# ENG-CDR21013-R3-GEC.pdf Markup Summary

C001

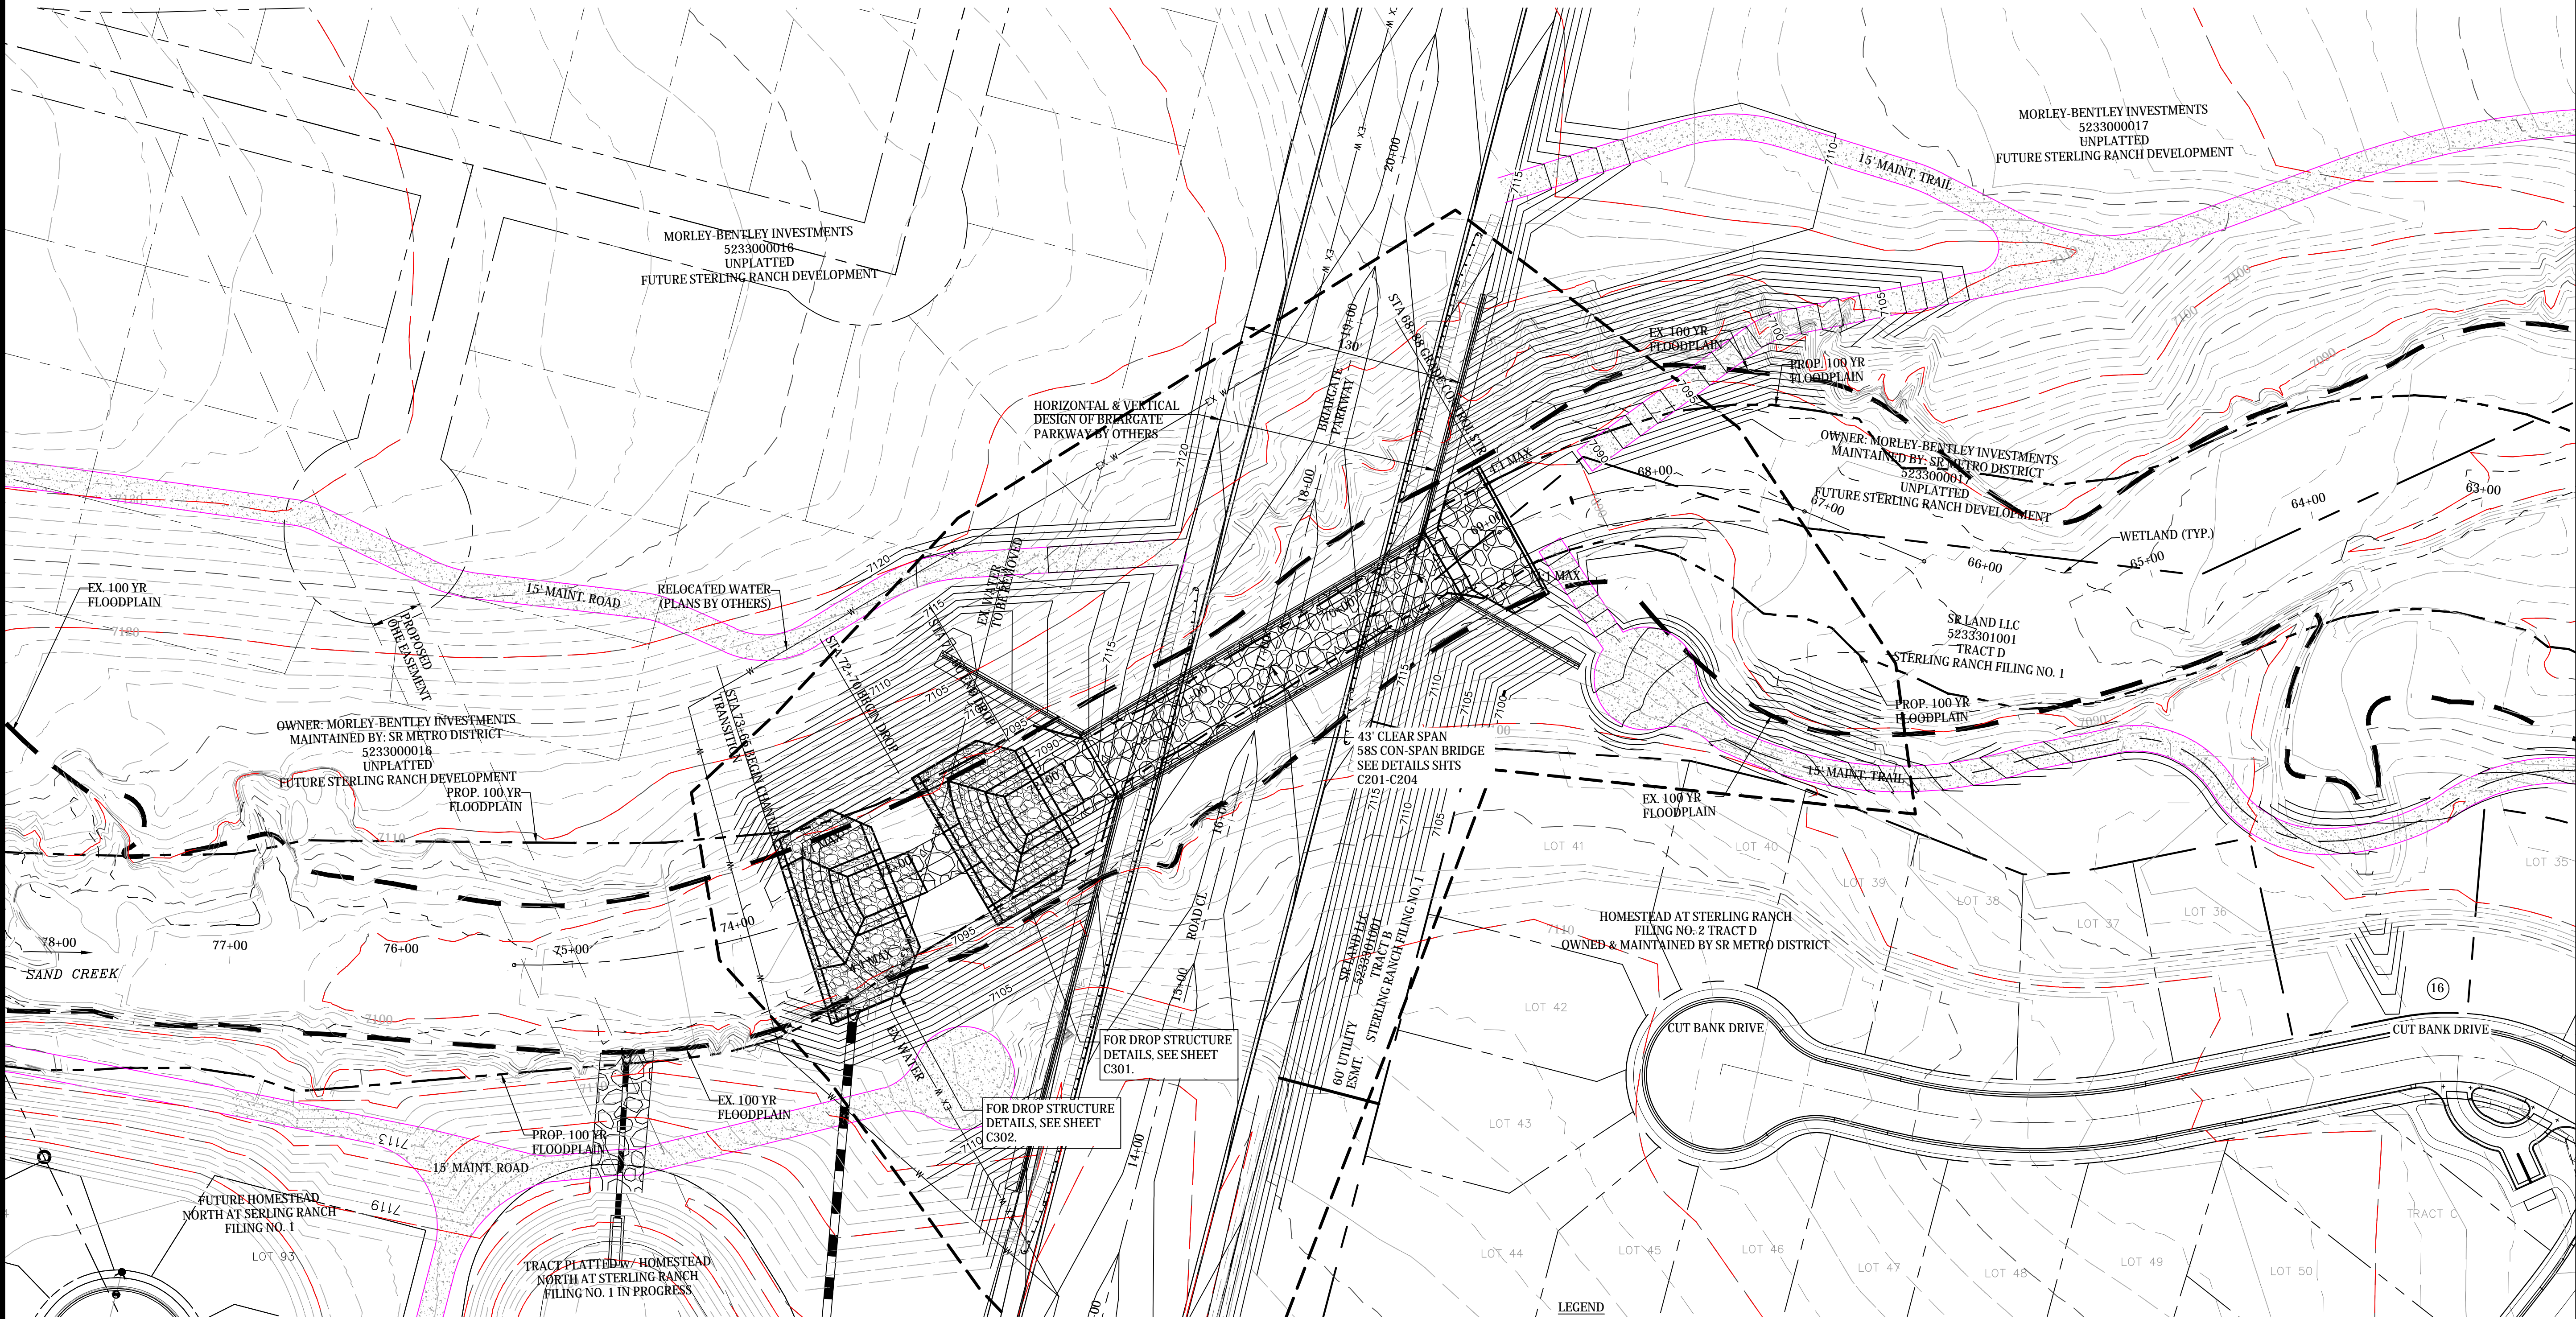
Construction limits don't match limits of grading.

add proposed floodplain

check linetypes

Where are seeding and erosion blanket limits shown?

What protection is proposed downstream work in channel?

Verify grading compared to Briargate plans.

Show access road

If this road is being constructed show the whole road.

Show proposed ROW with a darker line

If this grading isn't being done with the bridge provide the interim grading only.

Only show the portion being constructed

Don't show these future lots
